CITY OF PORTLAND, MAINE
HISTORIC PRESERVATION BOARD

February 9, 2015

Re: New Construction – Energy Building; Porch Expansion – Doctor’s Residence

Align top of knee wall with top of sweep on sidewall

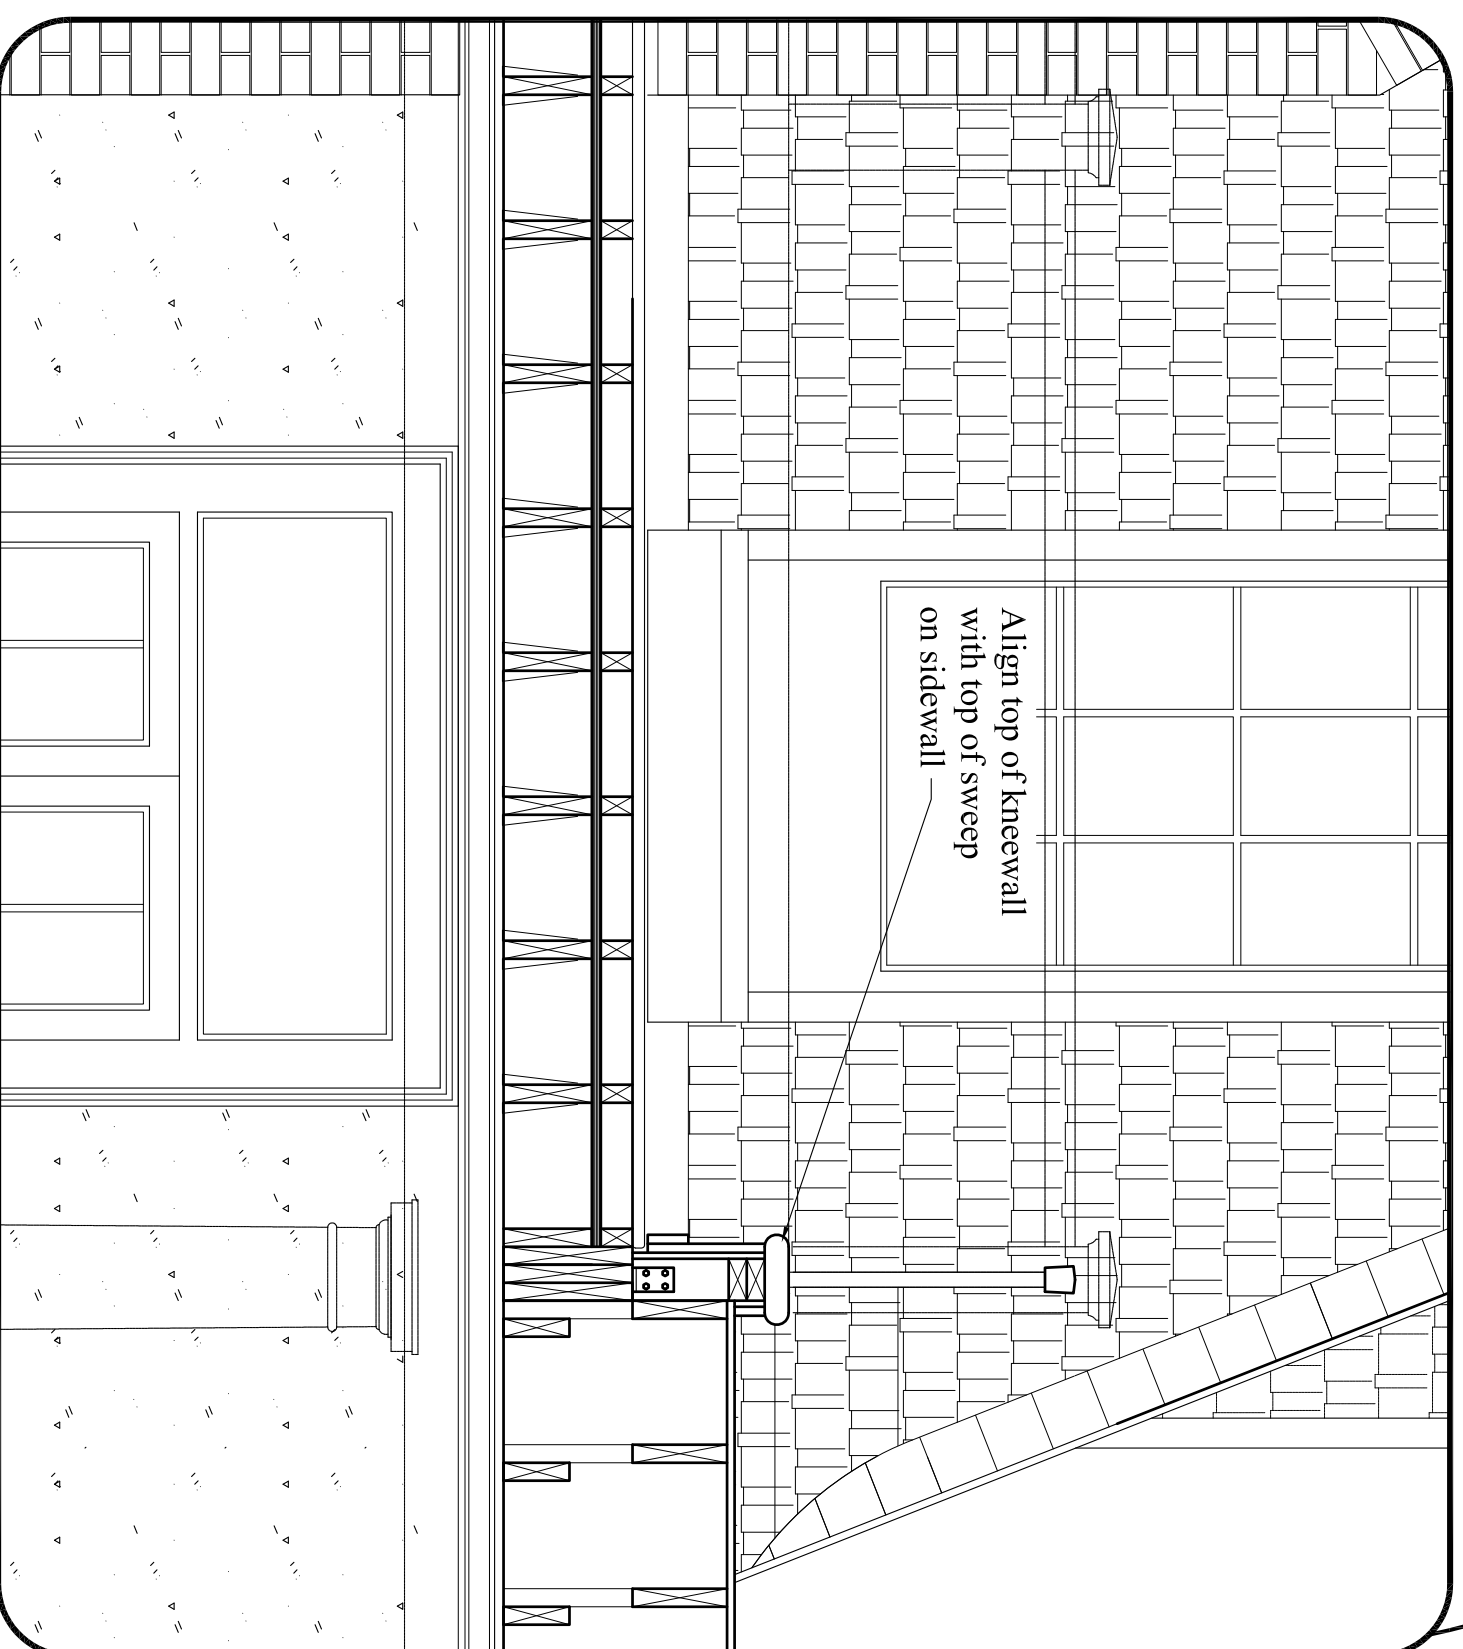
1. Approved Energy Building option includes a glazed cupola that is to be flared at the base, with the same siding treatment as the rest of the building.
2. Location and treatment of the proposed generator and its fuel storage are to be reviewed and approved prior to construction – by staff unless the generator and / or tanks are outside and above ground – in which case the generator plan is to be reviewed by the Board.
3. Balustrades on porches at the Doctor’s Residence are to retain / replicate the original spacing and appearance of the existing balustrades.
